From: Fiona Pudge <Fiona.Pudge@sportengland.org>
Sent: 10 September 2020 17:10
To: Laura Eastwood <Laura.Eastwood@ribblevalley.gov.uk>
Subject: RE: App Ref: 3/2020/0315 - The Rhyddings Langho BB6 8AF - Sport England Ref: PA/20/NW/RV/55804

Proposed Site Plan - 1:1000

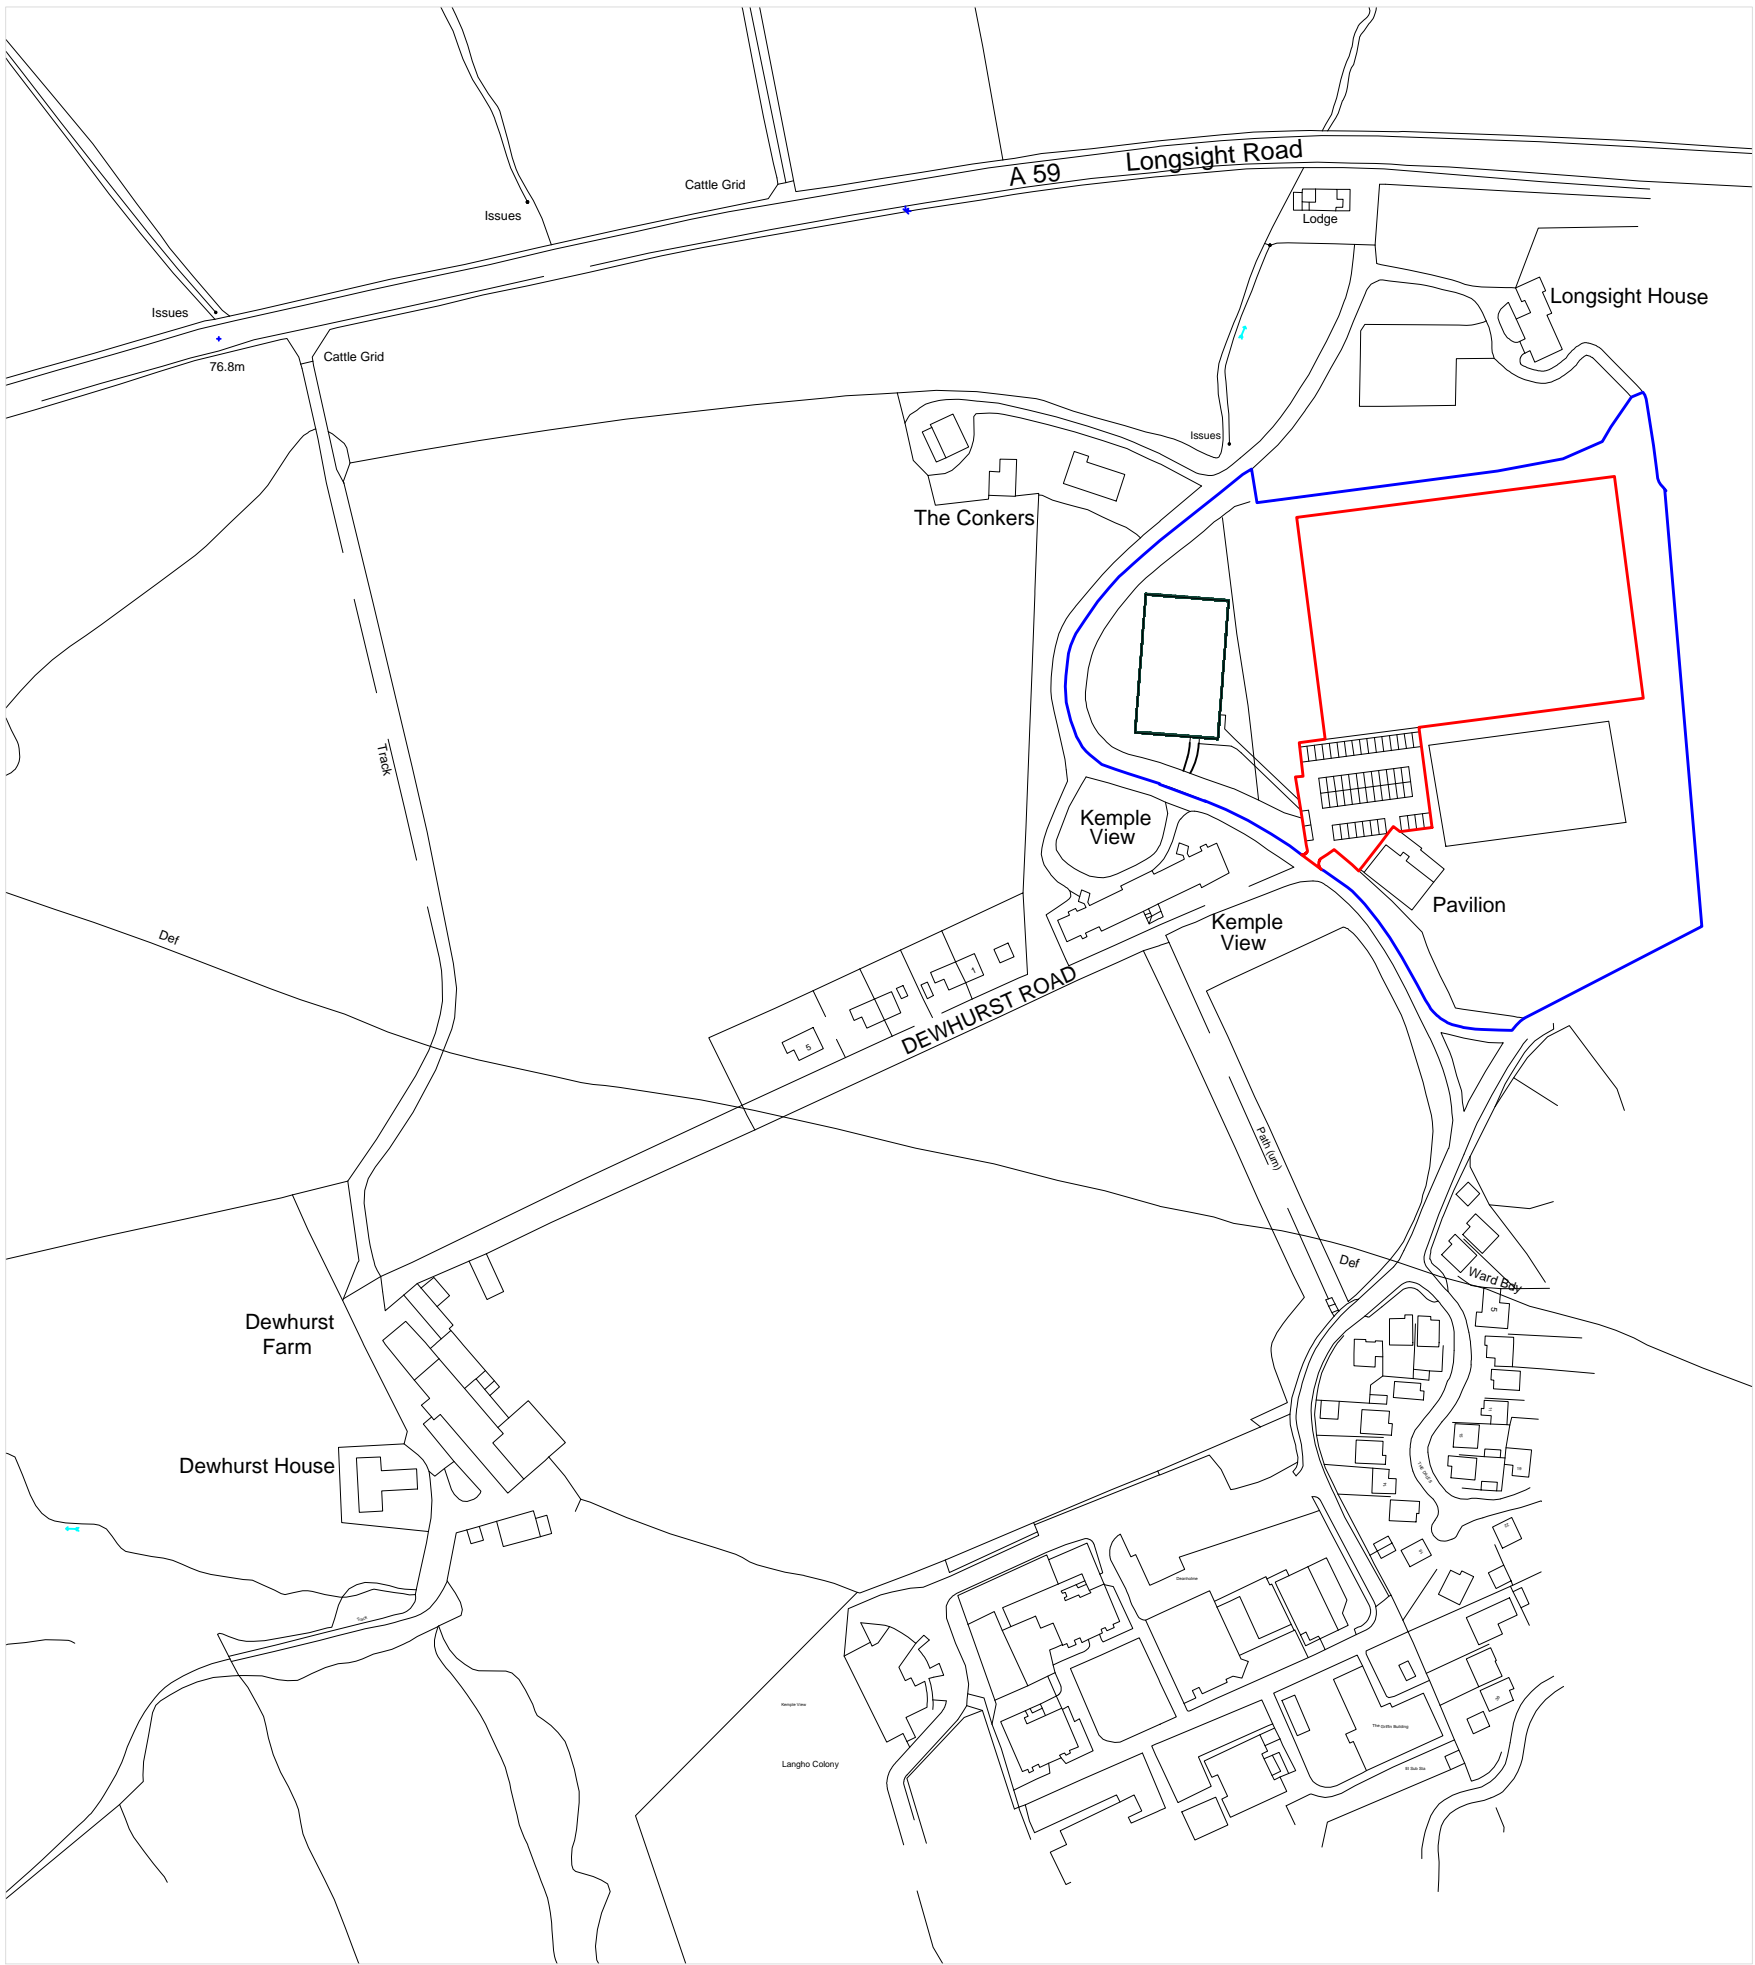
- The proposed AGP line markings are not as per our recommended guidelines
- The FA and Football Foundation recommend that over-marking is made to allow different formats of football (e.g. 5v5, 7v7, 9v9 and 11v11). Over-marking should adhere to The FA Guide to Football Turf Pitch Design Principles and Layouts.
- Presently the proposed design allows for full size and third markings. We would recommend the design is changed to reflect the above formats of football
- Mechanism to ensure accessible and affordable access to the Artificial Grass Pitch to community users

Although the technical specifications have been submitted the Football Foundation has identified some areas where the specification does not meet FA standards. For that reason, the following condition is required to ensure the specification is amended and submitted to ensure the Artificial Grass Pitch will be fit for its intended purpose. The applicant is advised to liaise with the Football Foundation to ensure the specification is acceptable prior to submitting the details to discharge the condition.

No development shall commence until details of the design and layout of the Artificial Grass Pitch have been submitted to and approved in writing by the Local Planning Authority after consultation with Sport England. The Artificial Grass Pitch shall not be constructed other than in accordance with the approved details.
